**From:** elliottr [elliottr@kvfr.org]  
**Sent:** Friday, November 04, 2011 9:03 AM  
**To:** Dan Valoff  
**Cc:** Brenda Larsen; seemillerj; John Sinclair  
**Subject:** SP-11-00011

Dan – I received the Notice of Application for the HC Trust Short Plat at the corner of Parke Creek and Christensen roads. KVFR does not have code enforcement authority in this area but I am recommending the following issues be addressed:

H&C TRUST SHORT PLAT A PORTION OF THE NORTHEAST 1/4 OF SECTION 33, TOWNSHIP 18 NORTH, RANGE 20 EAST, W.M., KITTITAS COUNTY, WASHINGTON

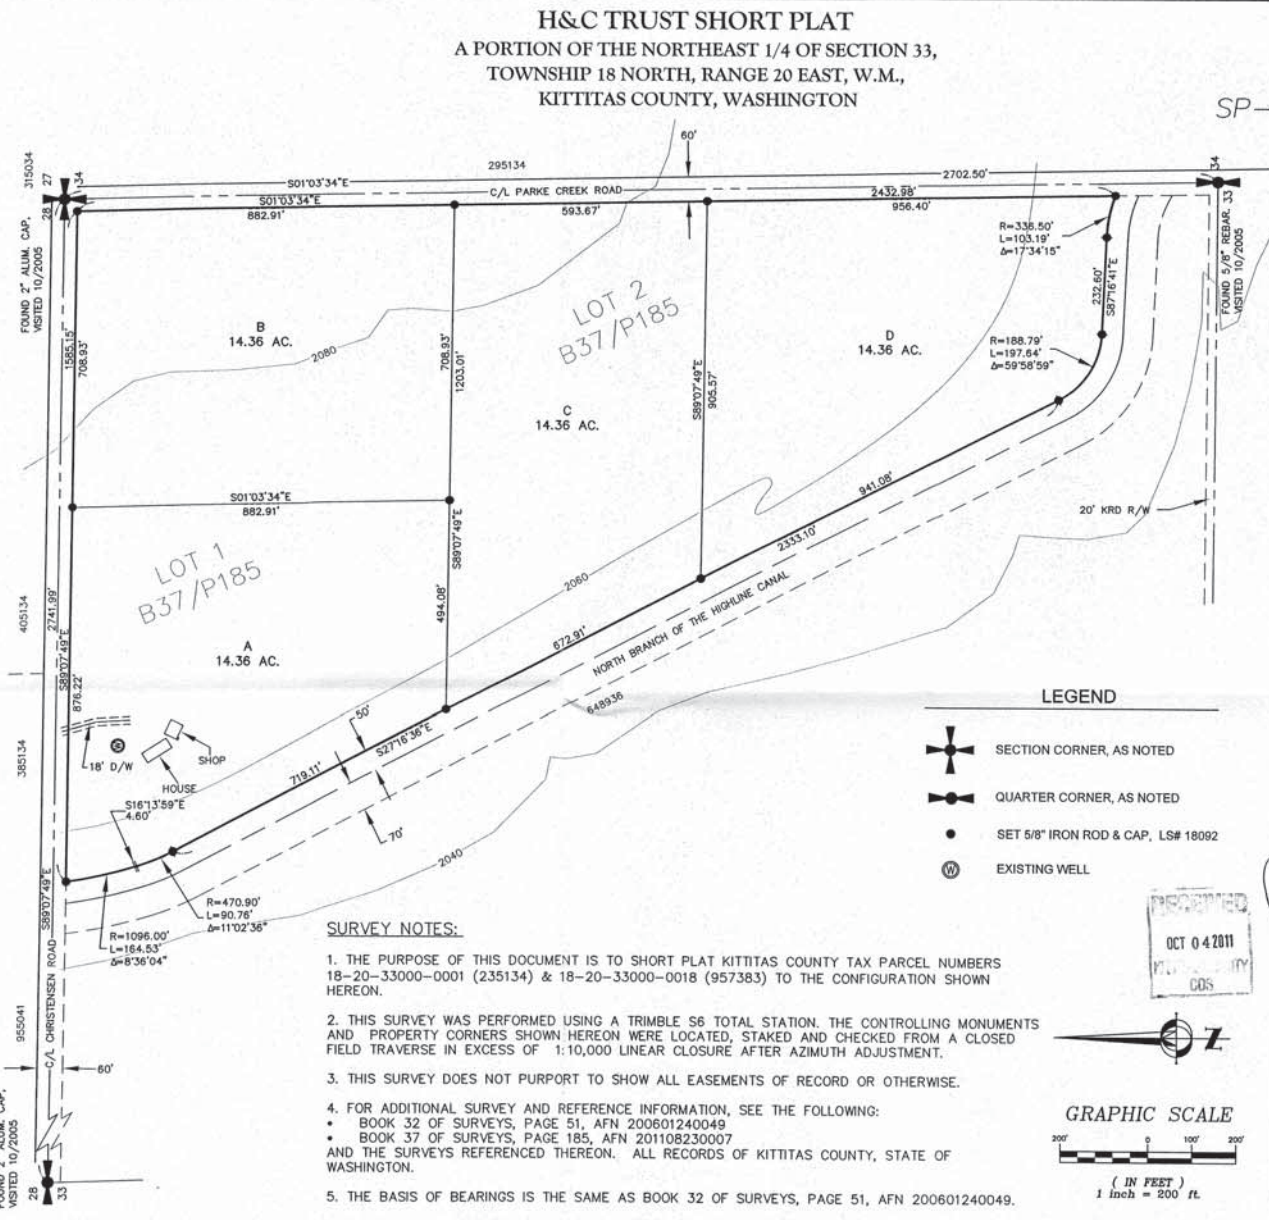
1. The property access will need to comply with applicable IFC's Appendix D.
2. Addressing for all plats will need to be visible from each direction of travel.
3. The plats are located in an area that is a long way from both volunteer and career staffed fire stations resulting in extended response times. The property is also located in a wild land interface area. Water supply will need to be addressed and sprinklers will be strongly recommended for any structures on any of the lots.
